Project #: 1008952 Application #: 14DRB-70138, 14DRB-70139

Project Name: NORTH ALBUQUERQUE ACRES

SUBJECT: Project # 1008952 - Morningstar

DATE: May 12, 2014

SITE PLAN FOR BUILDING PERMIT

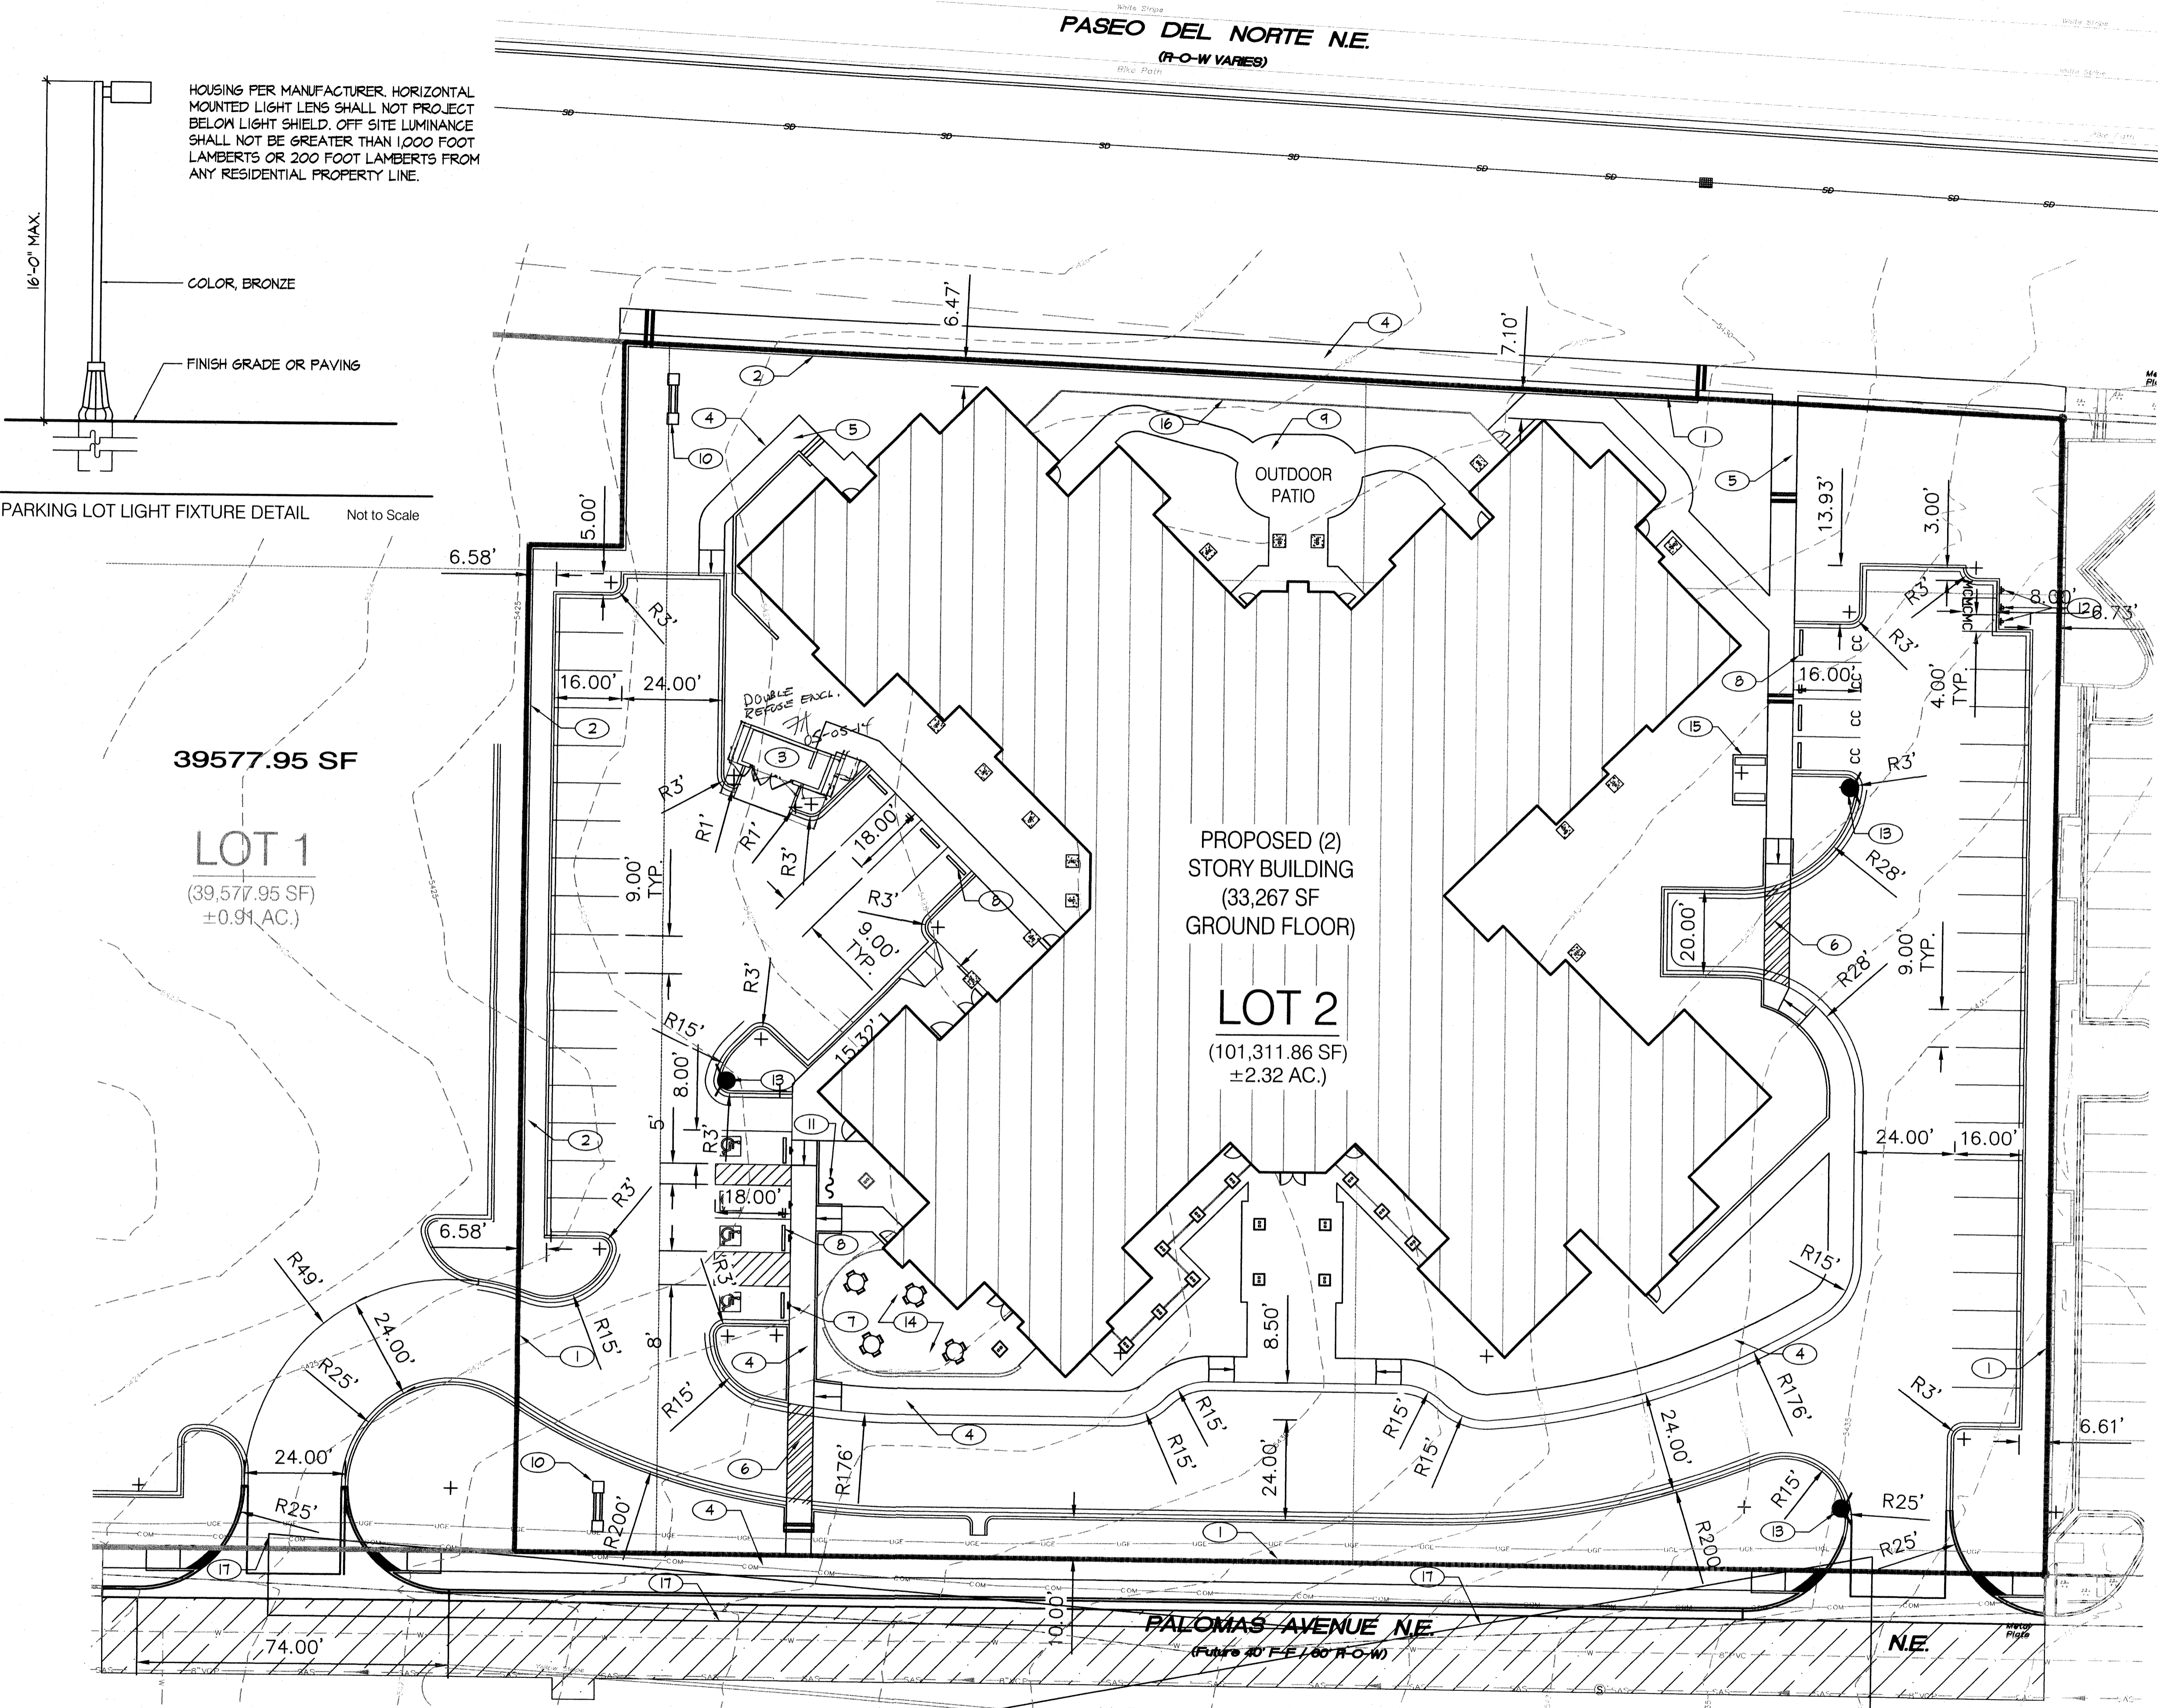
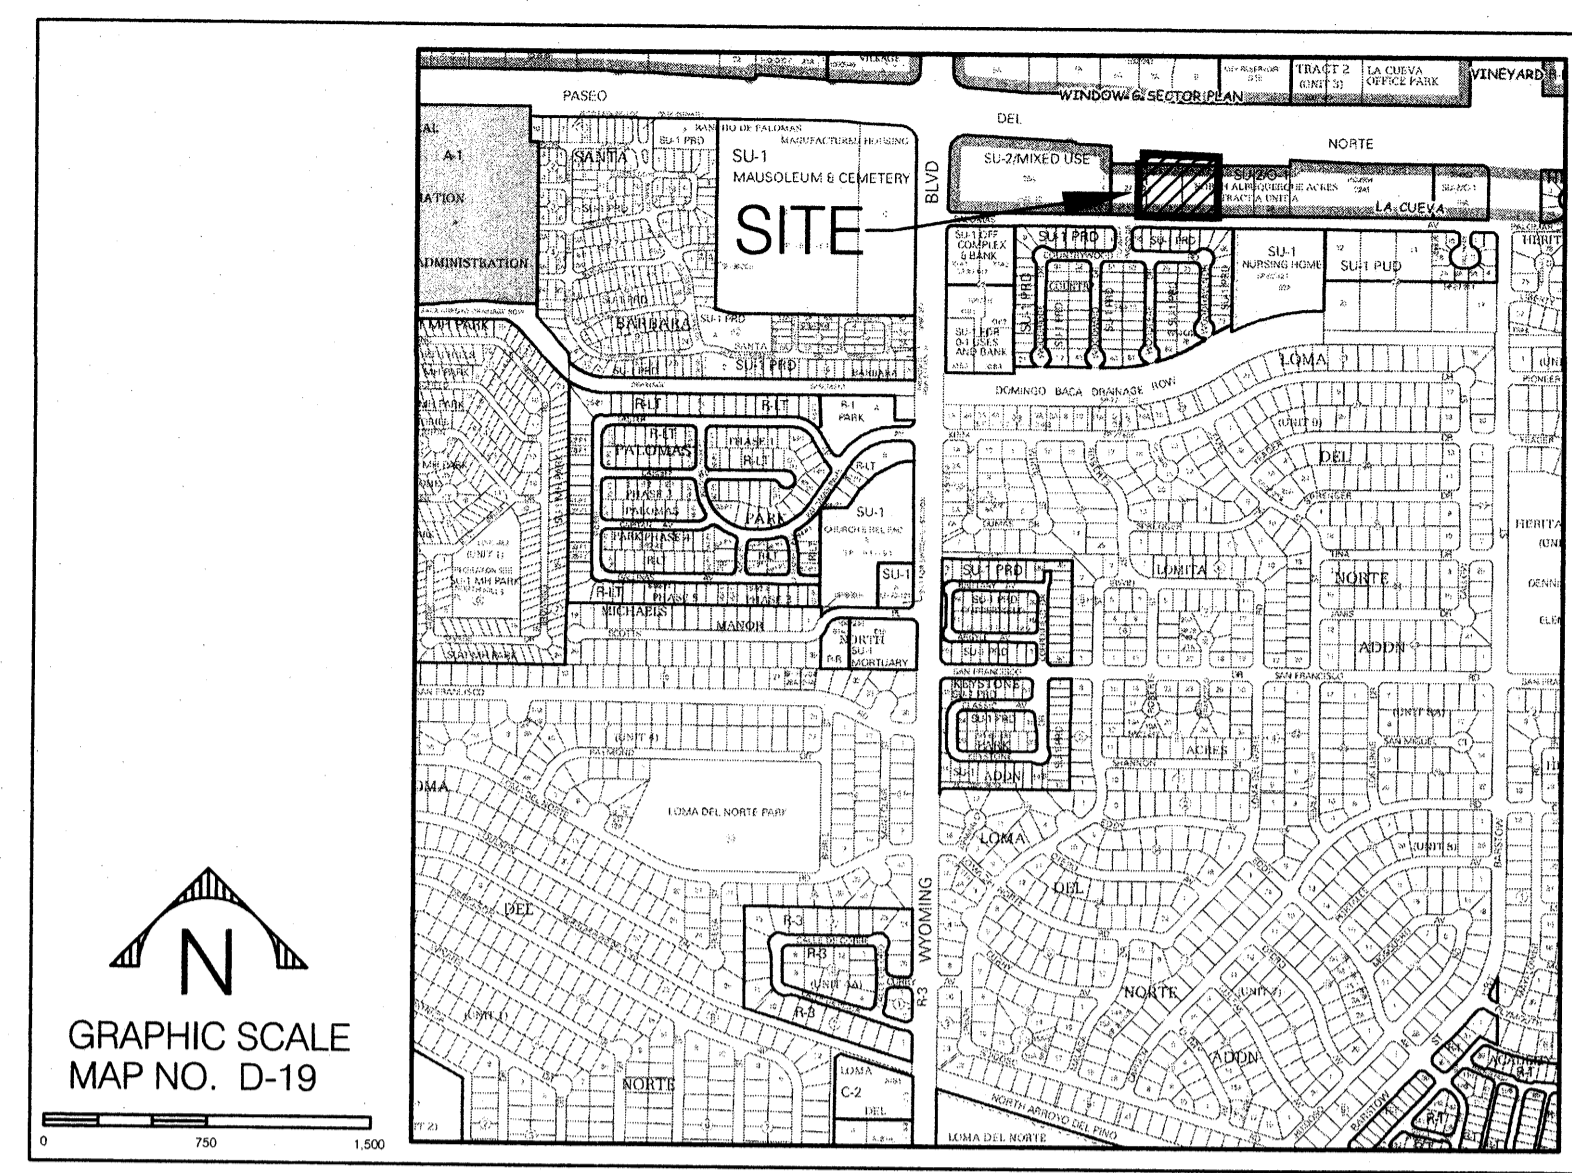
1. Condition 6 has been addressed. A sidewalk connection has been added to the plan that connects to the sidewalk on Paseo Del Norte.
2. Condition 7 will be addressed during the DRB process with the concurrent platting action.
3. Condition 8, the note has been added to the plan. The clear site triangles are shown on the site plan and the landscape plan but need to be labelled. That will be done prior to DRB approval.

PLAT OF
 LOTS 25-A, 26-A, 6-A & 8-A
 NORTH ALBUQUERQUE ACRES, TRACT A, UNIT A
 PROJECTED SECTION 19, T. 11 N., R. 4 E., N.M.P.M.
 ELENA GALLEGOS GRANT
 CITY OF ALBUQUERQUE
 BERNALILLO COUNTY, NEW MEXICO
 OCTOBER 2011
 SHEET 1 OF 2

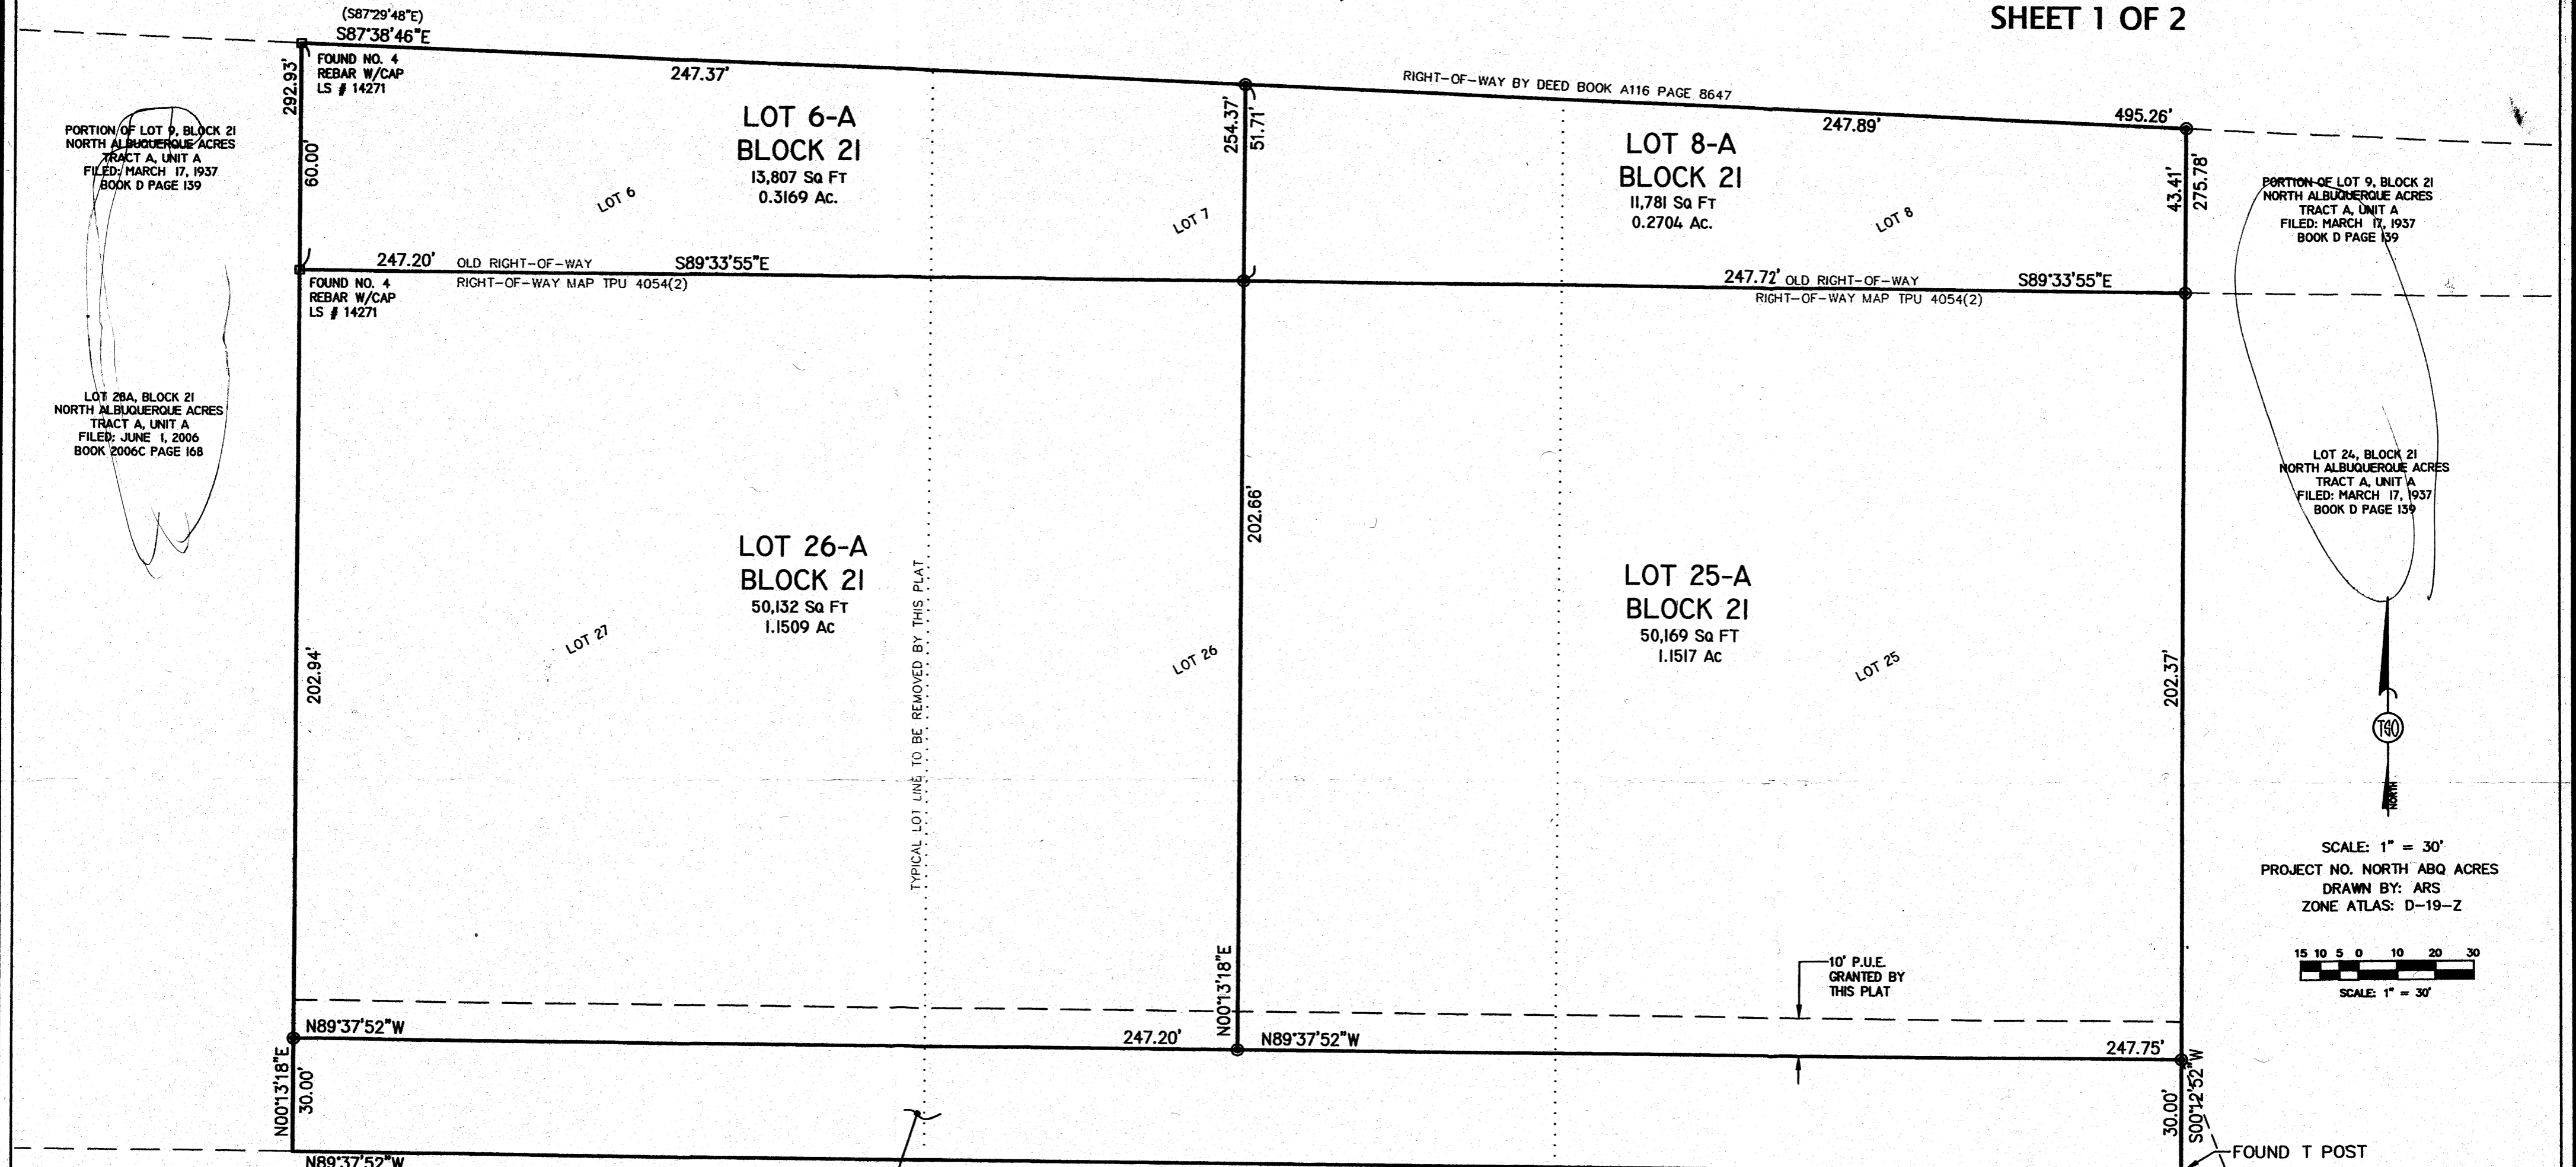
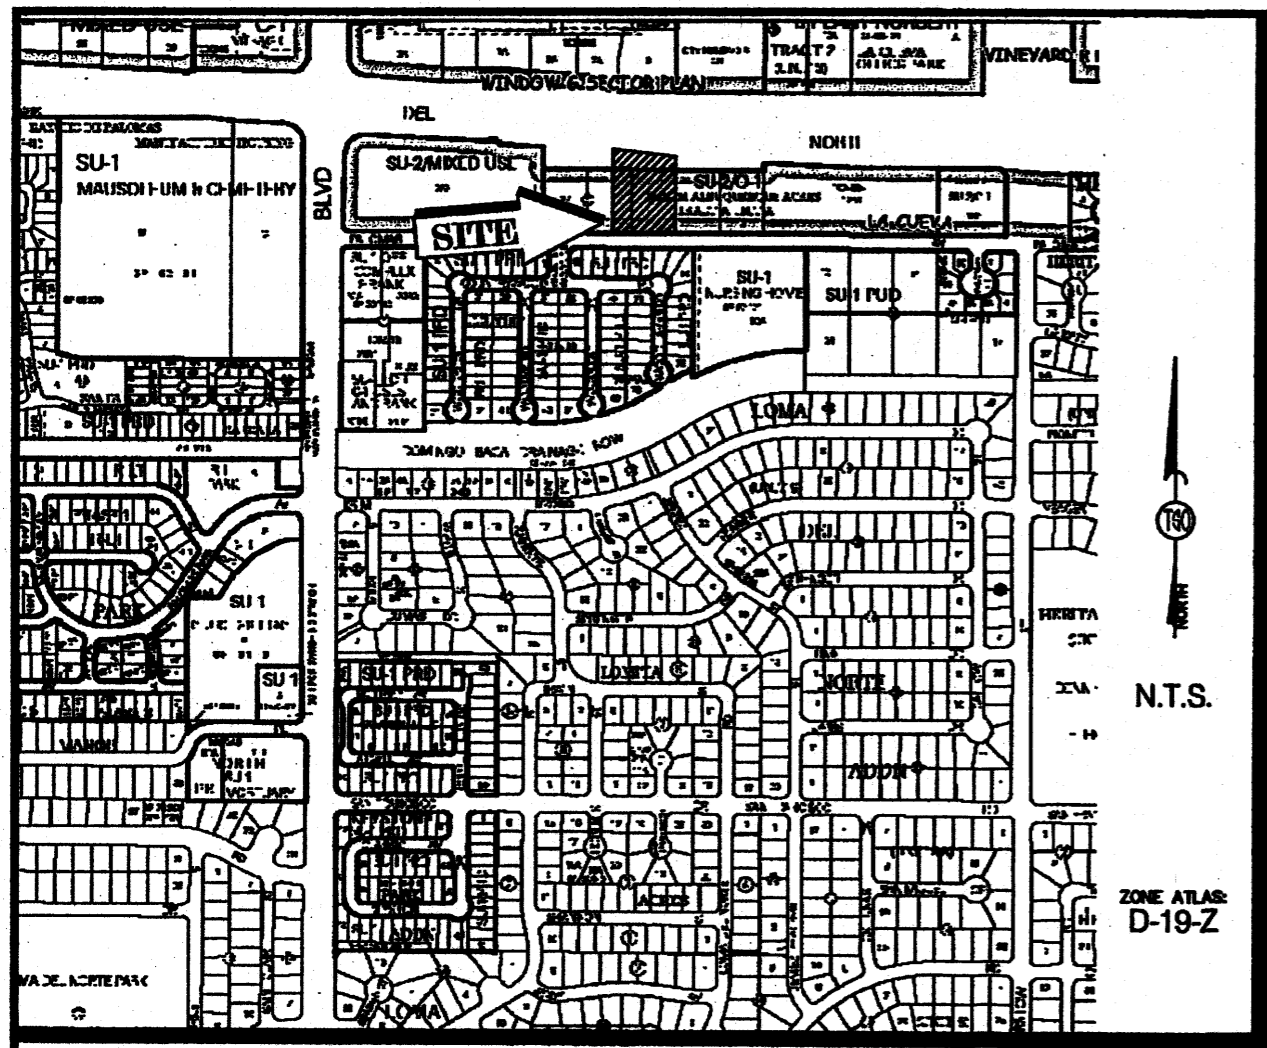
The Plat Title is incomplete as it does not include the Block number. Adjoin lots on the plat need to be updated to show current legal descriptions.

The plat is not consistent with the Subdivision Notes – there should only be 2 lots, with the northern remnants combined with each southern counterpart. The northern lots as shown are undevelopable and therefore unsuitable for subdivision.
